STATE OF NORTH CAROLINA
DEPARTMENT OF TRANSPORTATION

February 16, 2018

Subject: Modification request for Section 404 Nationwide Permits 12 and 14 and Section 401 Water Quality Certification for the construction of the US 401 improvements in Fayetteville, Cumberland County TIP No. U-4405. Debit \$570 from WBS 39049.1.1.

Reference: Section 404 USACE Action ID. SAW-2011-01806, issued December 1, 2017
Section 401 NCDWR Project No. 20171365, issued November 15, 2017

PERMIT DRAWING  
SHEET 8 OF 18

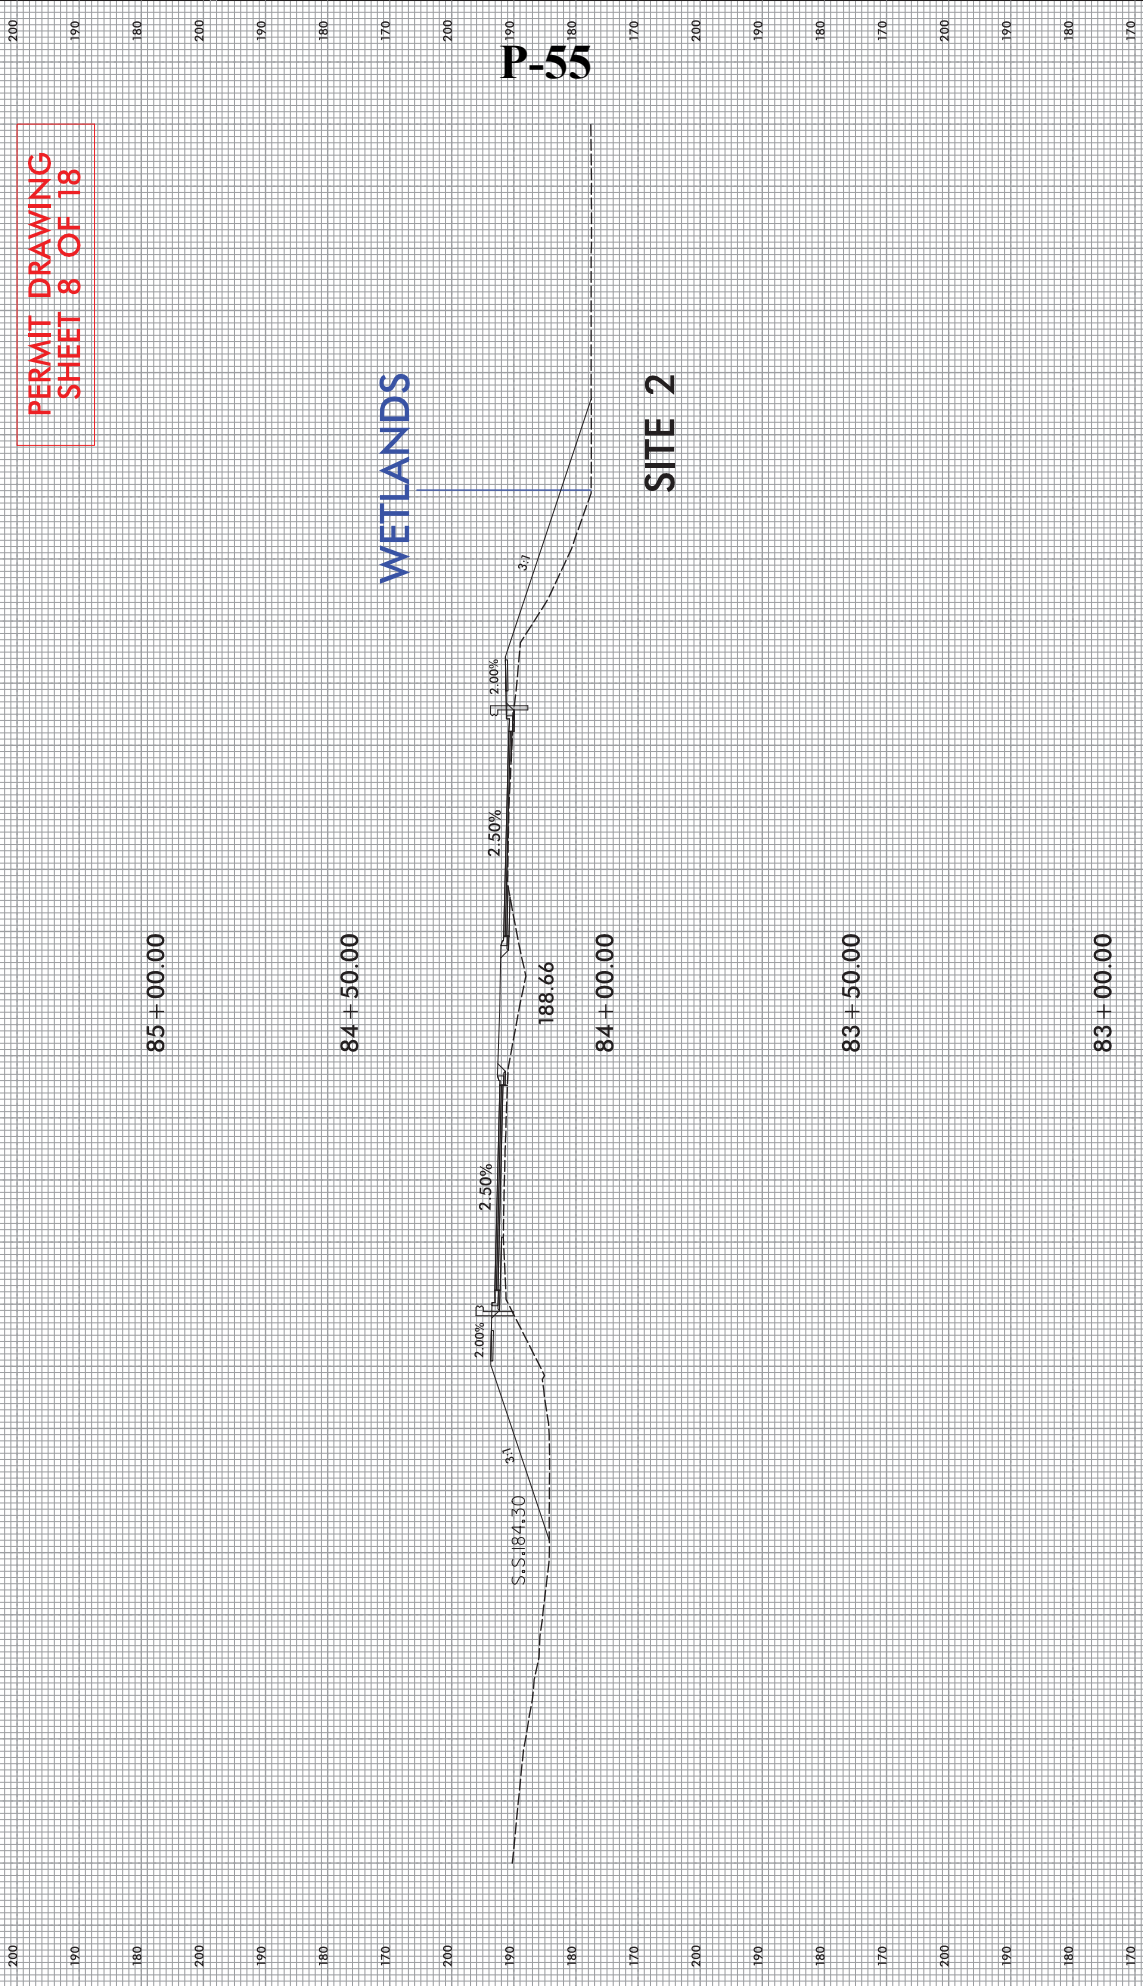
Site 2: An additional 10 feet of temporary stream impacts have been added at the downstream end. The temporary channel impacts and surface water impacts have increased in the summary sheet by 10 feet and 0.01 acre.

**PERMIT DRAWING  
 SHEET 15 OF 18**

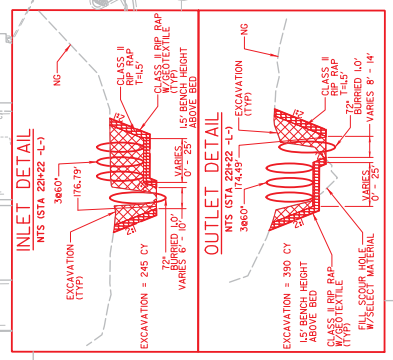
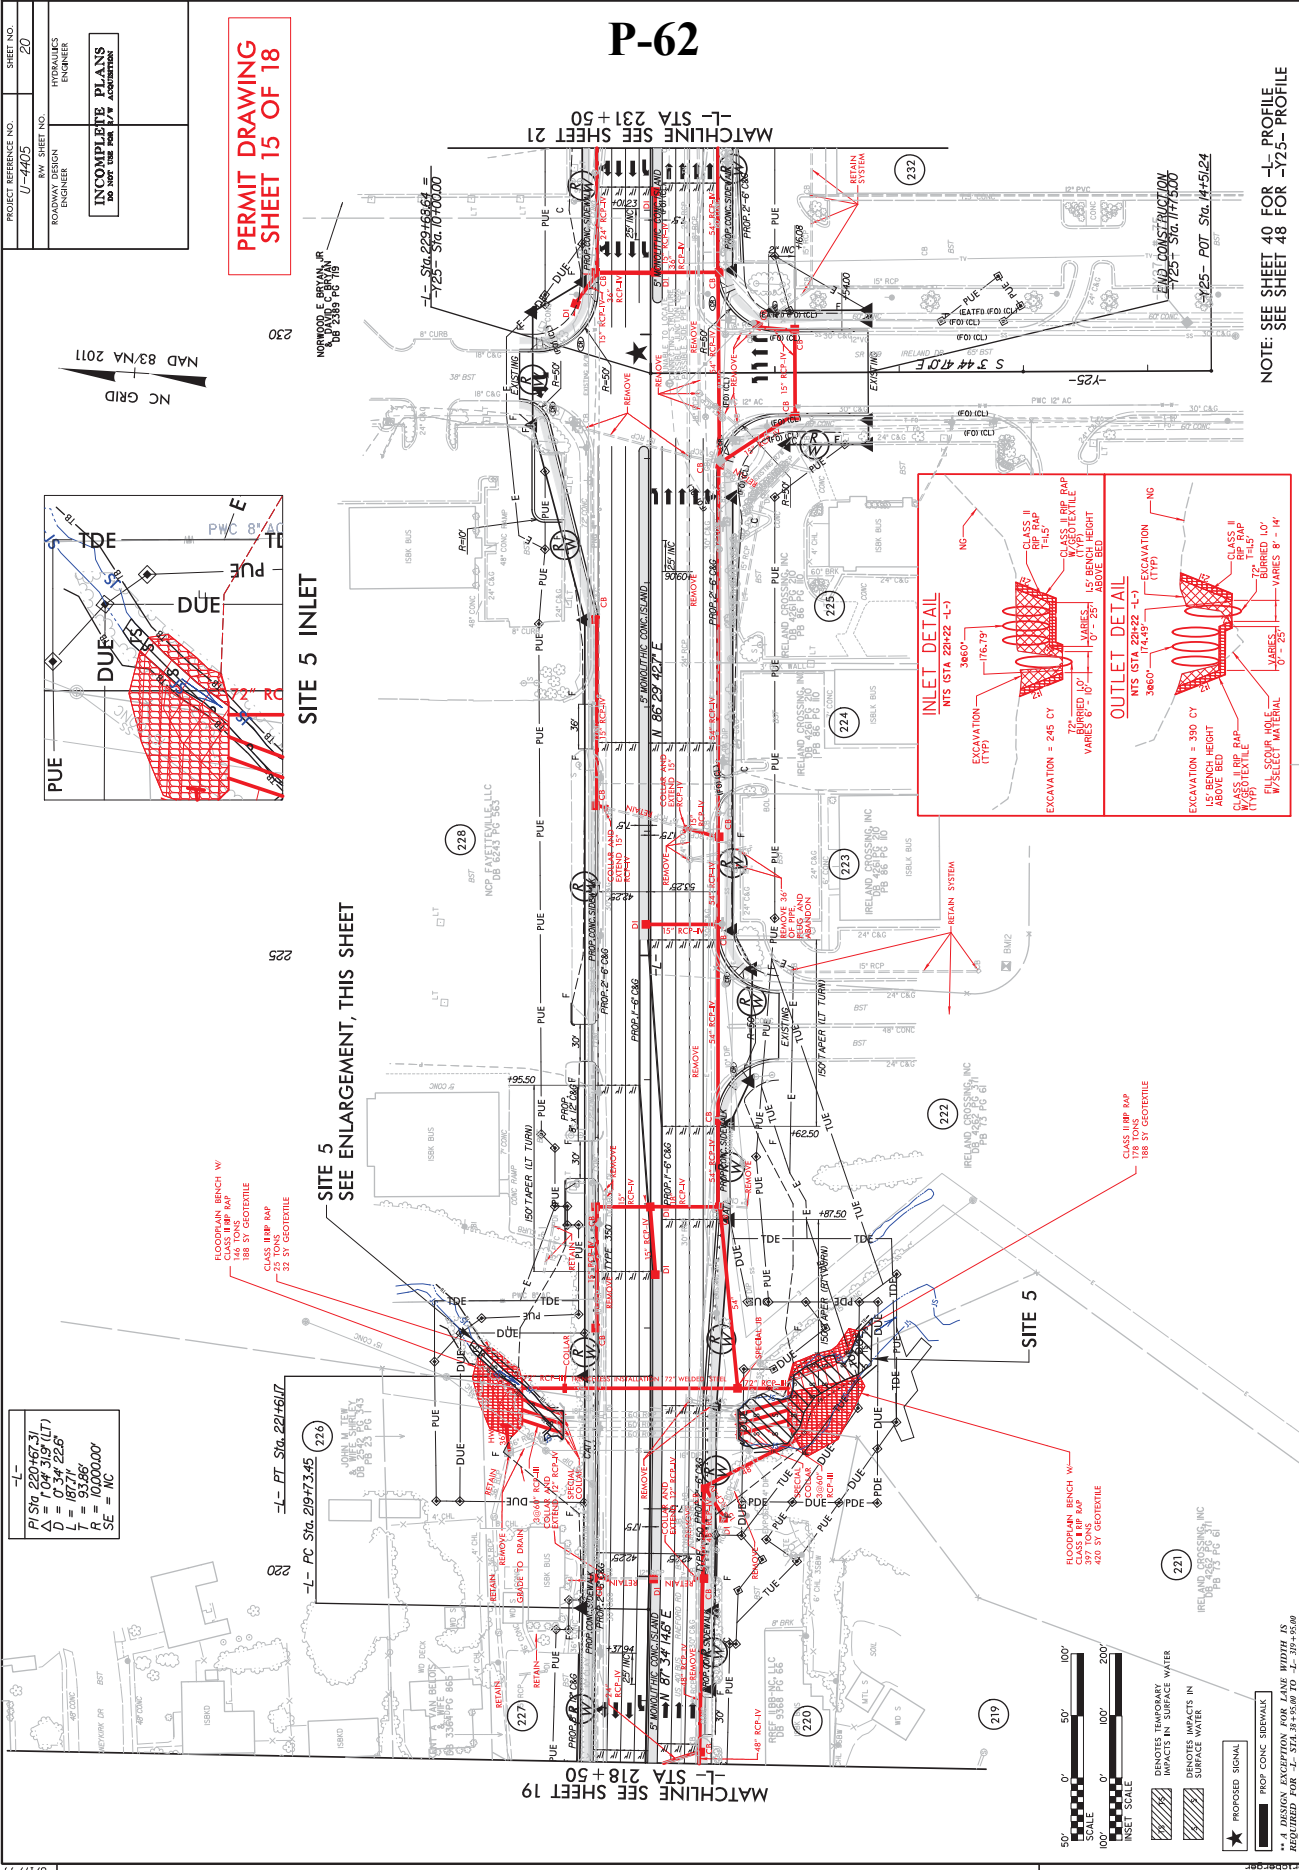
Site 5: The temporary stream impacts were extended on the upstream end (previously stopped just inside the DUE, now extends between the DUE and TDE) and shortened on the downstream end (previously extended to area between DUE and TDE, now stops inside of DUE area). Temporary surface water impacts increased to 0.02 ac.
